Please ask for: Nicola Moore
Email: nicola.moore@arun.gov.uk
Telephone: Ext 37944
Our Ref: AW/49/21/HH
Your Ref:
Date: 16th March 2021

Application for Planning Permission for Works or Extension to a Dwelling

Development: Single storey rear extension
Location: 10 Wyde Feld Bognor Regis West Sussex PO21 3DH

location plan
1:1250

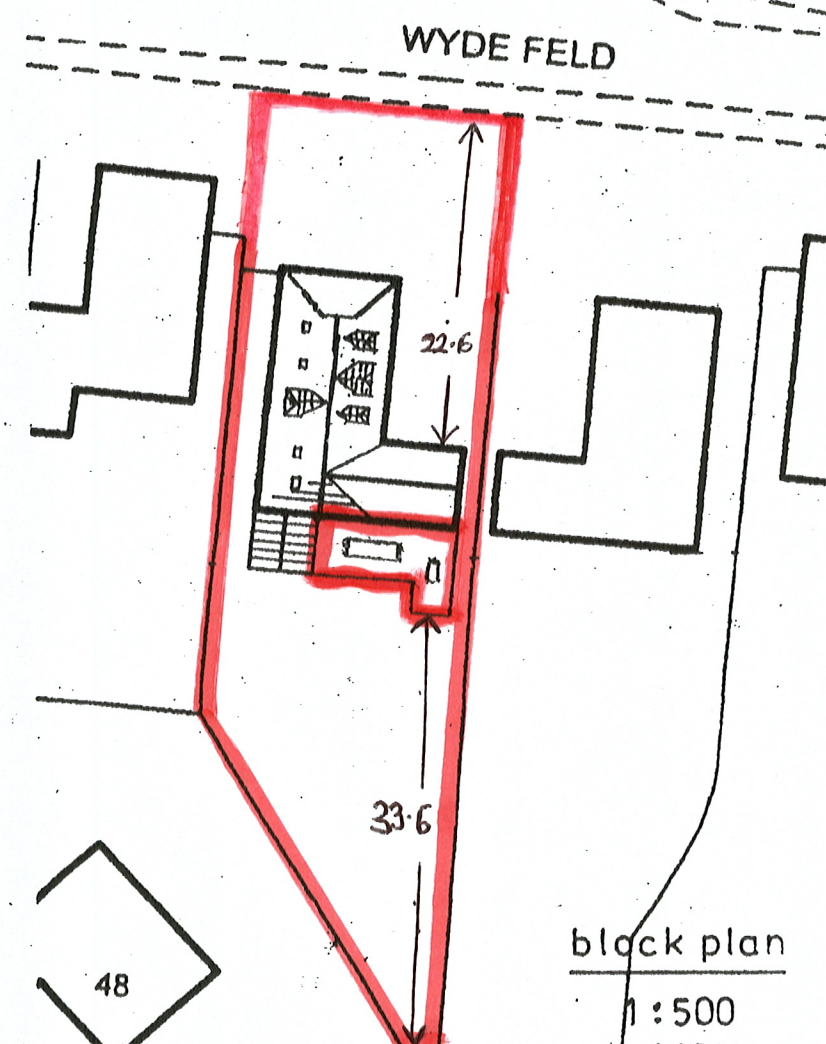
The red edge should include all land, including land required to access the property from a public highway. Please amend accordingly and re submit. Further details of what must be included on the plan can be found in the Validation Requirements List.

Written dimensions to boundaries are required from the proposed extension. Please amend accordingly and re submit. Further details of what must be included on the plan can be found in the Validation Requirements List.
